From: [REDACTED]
Sent: 02 March 2026 09:49
To: Planning; jonathan.hinder.mp@parliament.uk; Cllr Ian Brown
Subject: Planning Application 3/2026/0089 - Land at Highmoor Farm

Planning Application Reference No.: 3/2026/0089

Address of Development: Land at Highmoor Farm Clitheroe BB7 1PN

Client <b>MORRIS HOMES</b>			
Project <b>HIGHMOOR FARM, CLITHEROE</b>			
Title <b>SUDS Details - Sheet 1</b>			
Status	Suitability Description	Structural Stage	Date
PLANNING			16.01.2026
Designed By PB	Drawn By	Scale @ A1 AS SHOWN	Project No. 2936
Sheet No. 2936-SCE-00-00-DR-C-0072			Revision P02

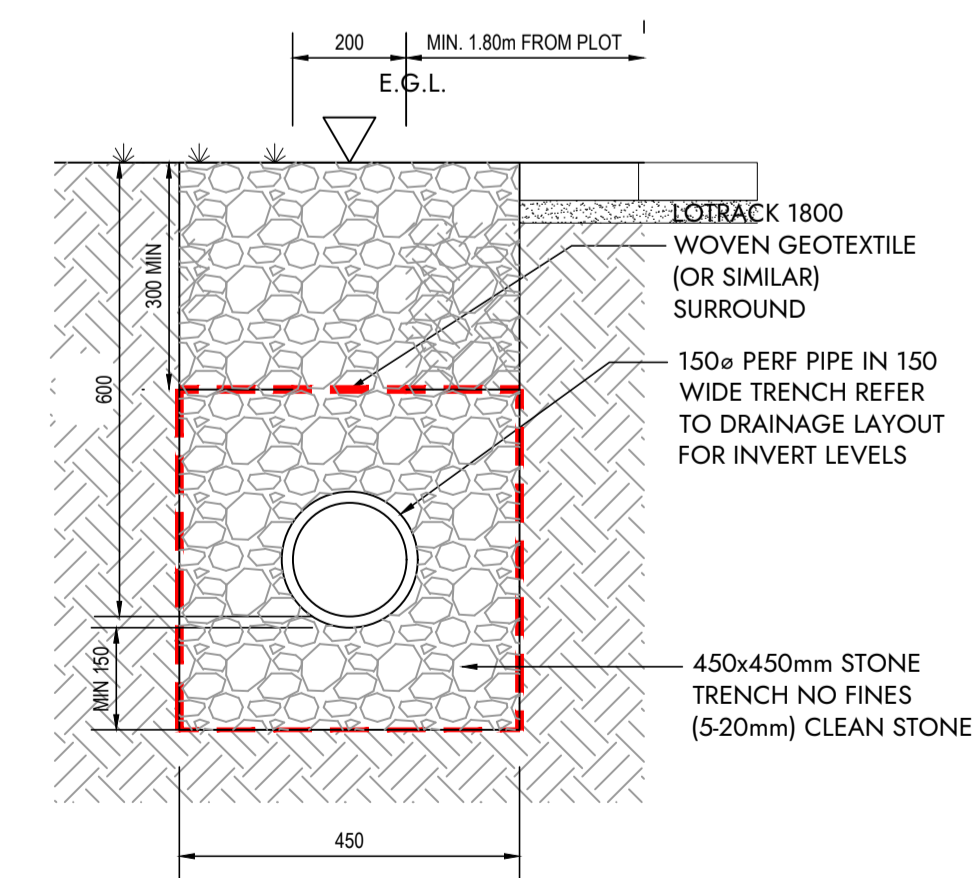
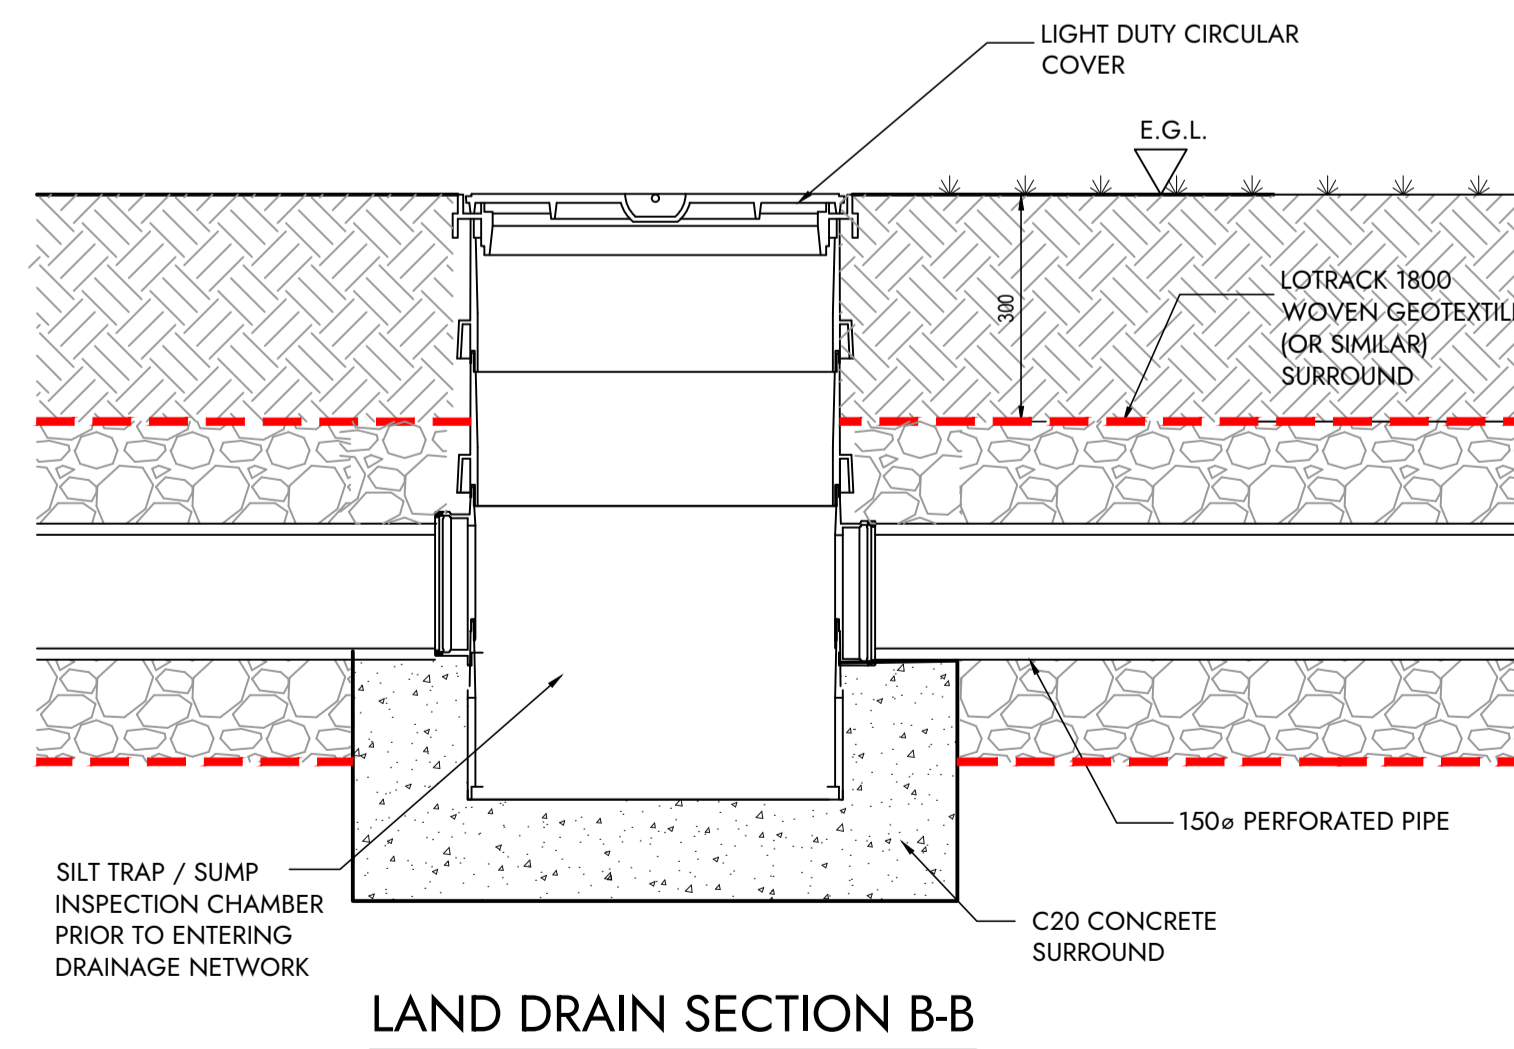
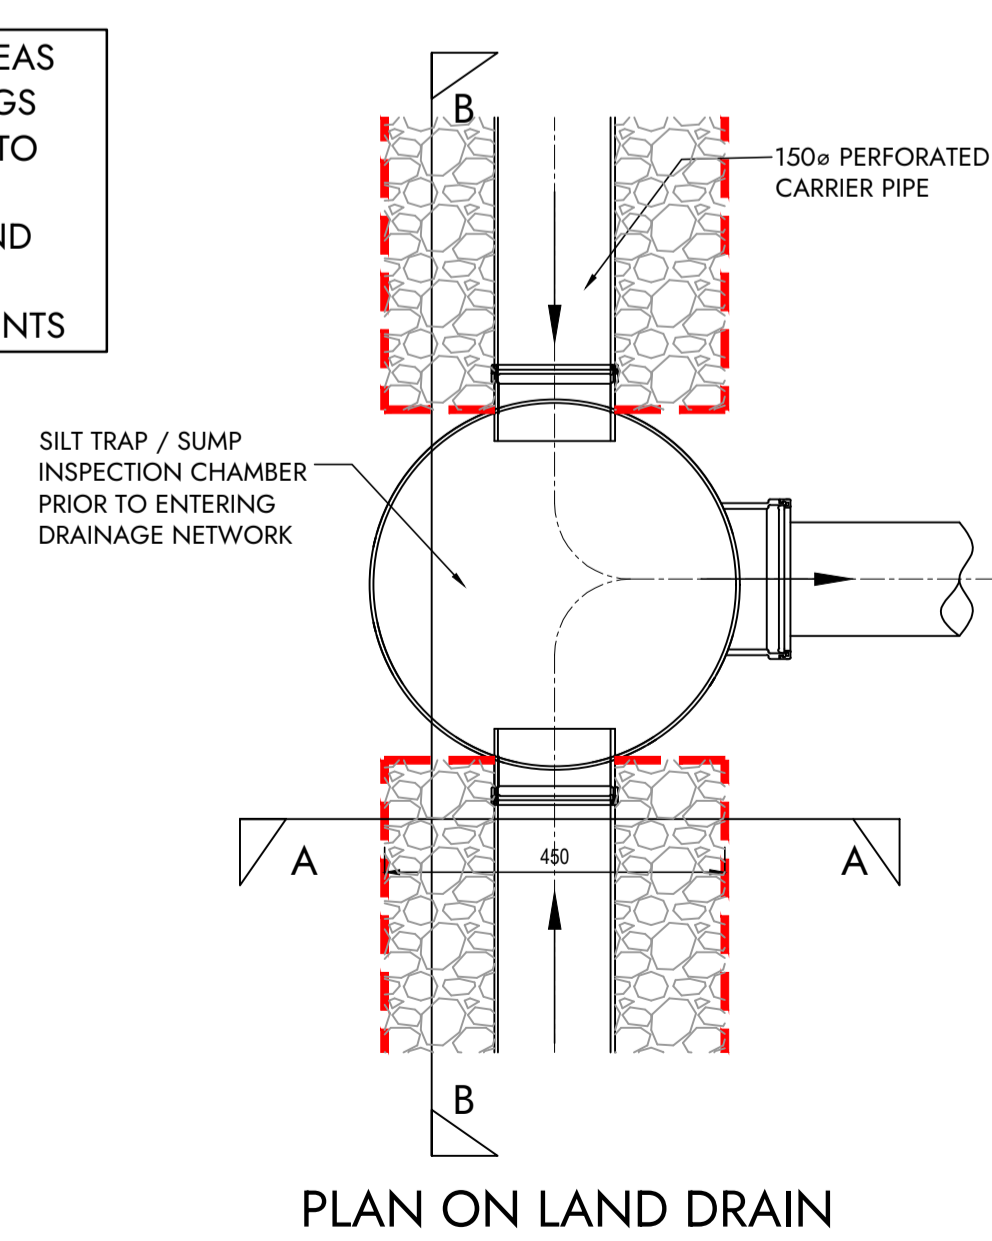
The SUDS Drainage plan seems to divert water from the balancing pond into the beck which then flows into the brook on Taylor Street. It is not clear who is responsible for the maintenance of this watercourse. But as you can see from the images below the waterway consists of several sections of varying widths, depths and standards of maintenance. Making it difficult to calculate the full impact

that the rediverted surface water of the proposed estate would have on the surrounding area if the balancing pond were to be inadequate or fail.

This proposed SUDS plan needs to be assessed by an independent expert. Because the design, build and maintenance of this poses a critical threat to the surrounding area if not executed correctly.

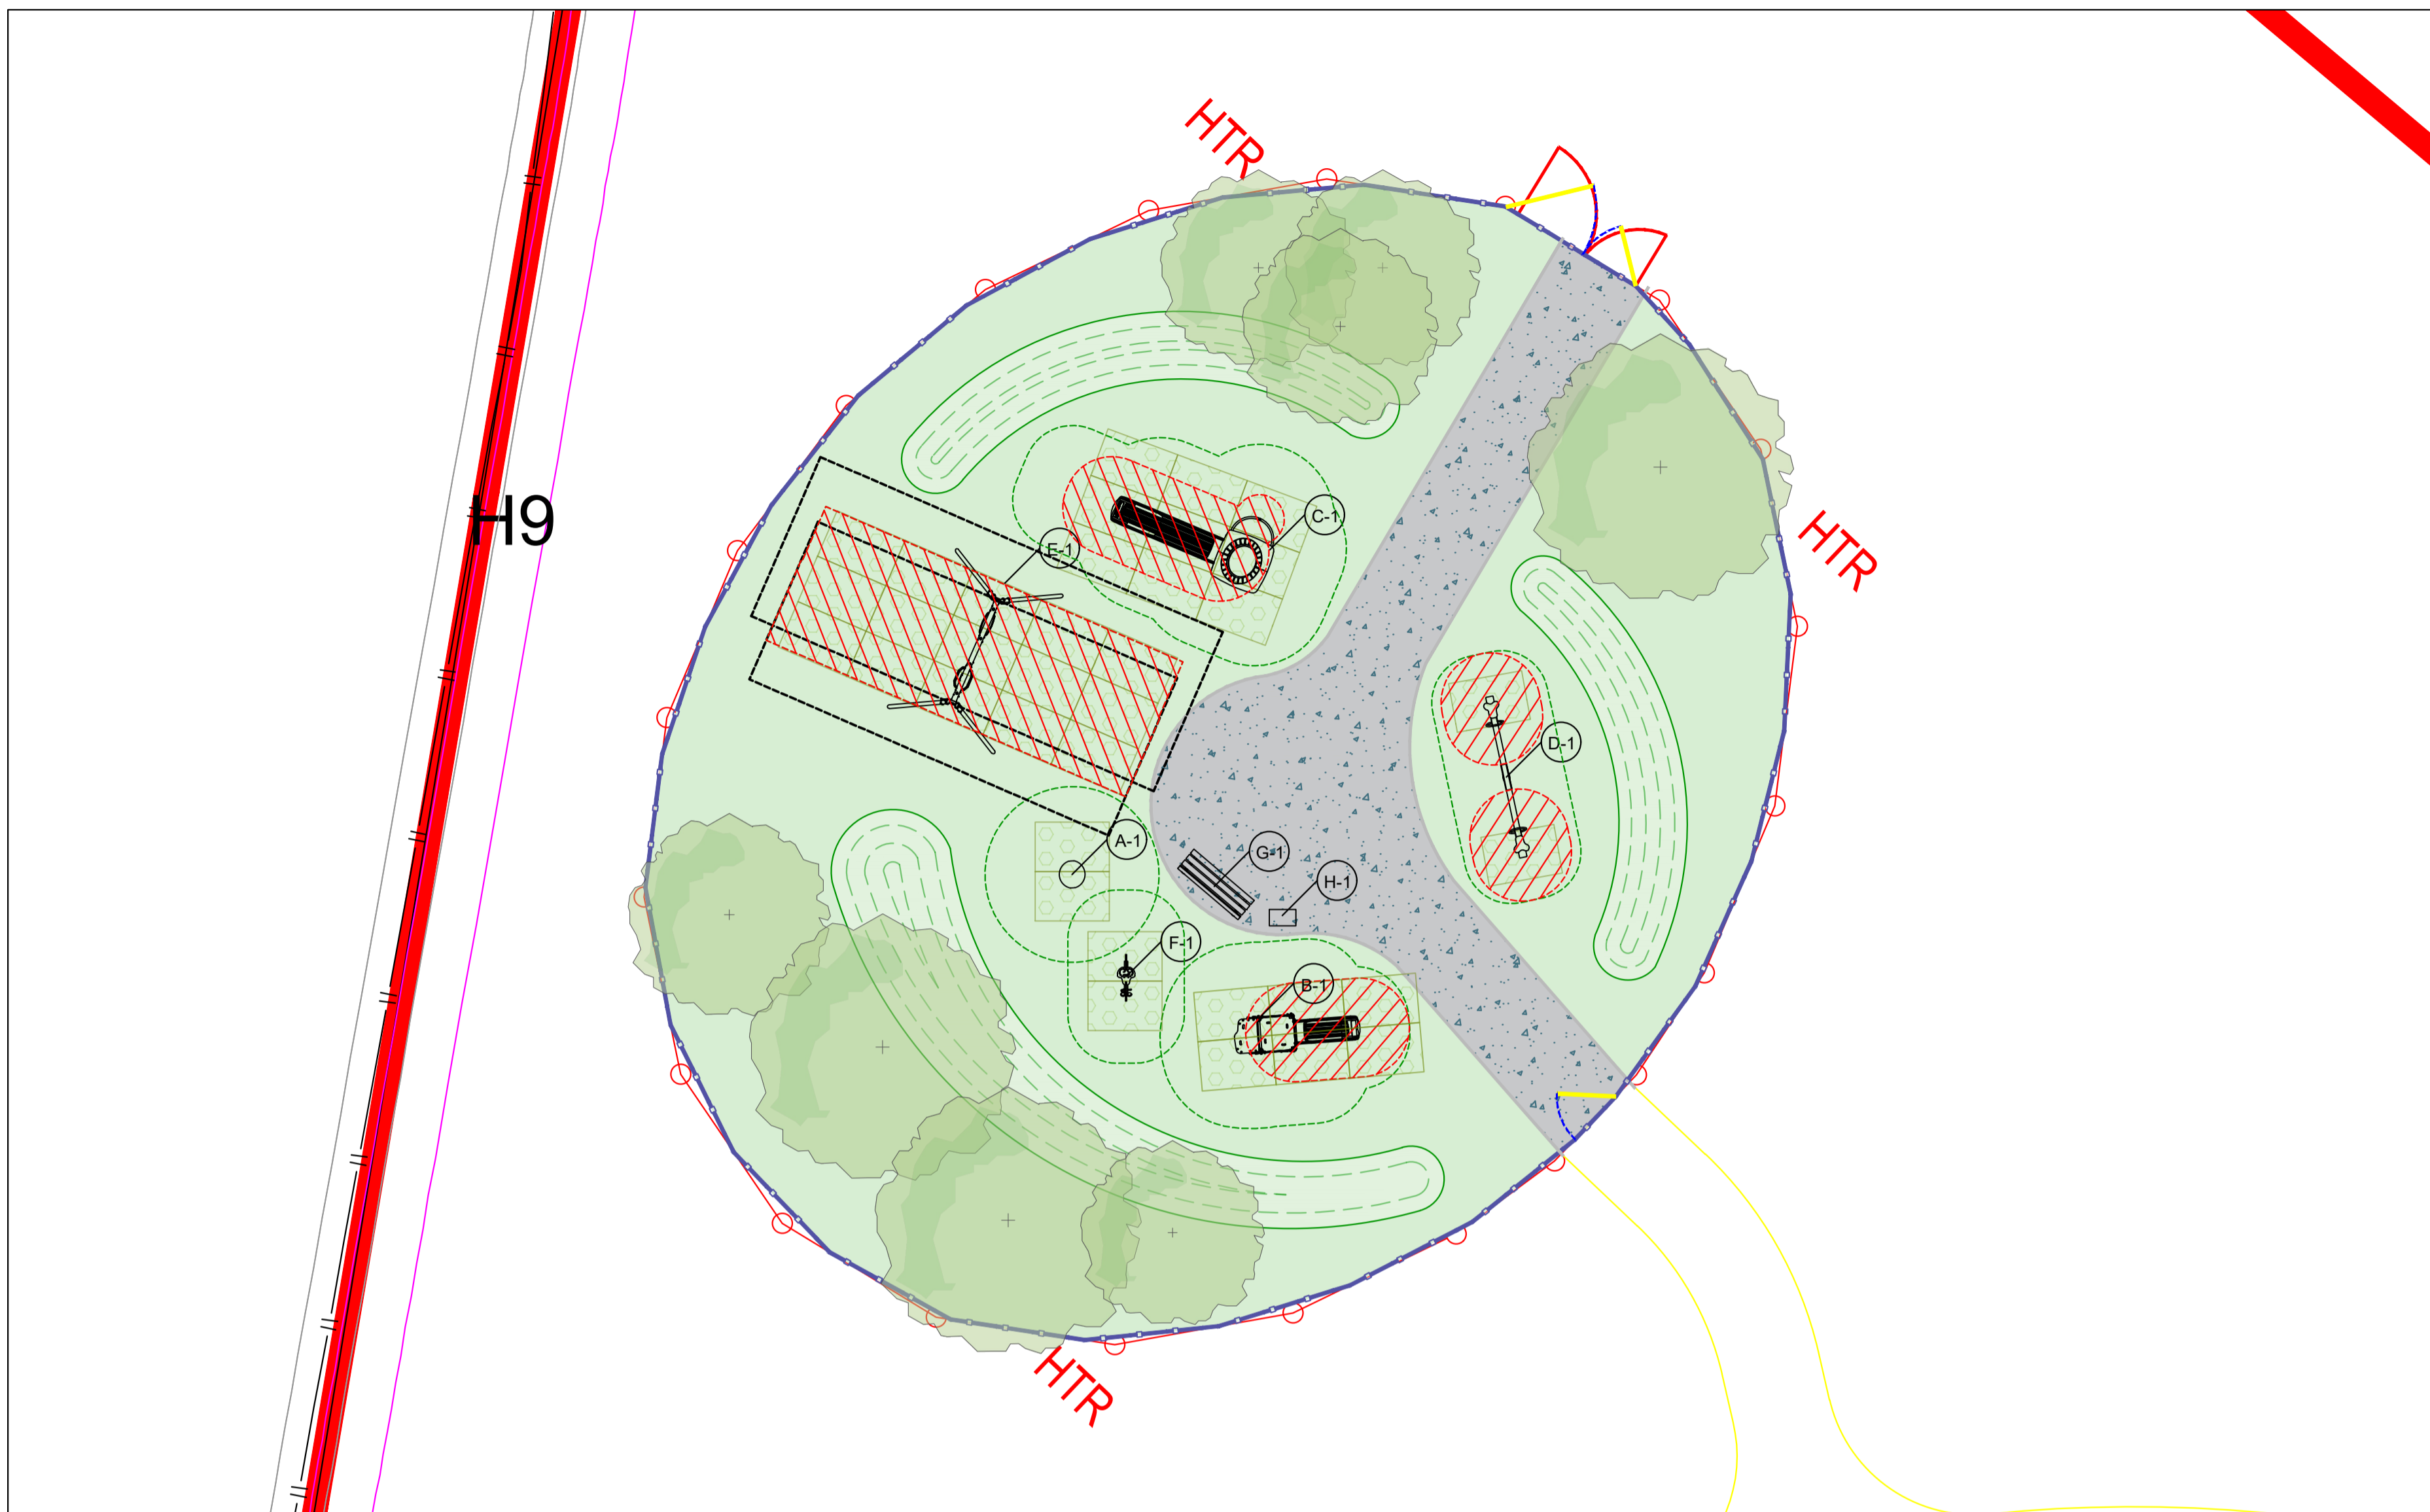
The location of the LEAP next to a beck and the balancing pond are a real safety concern for parents of young children.
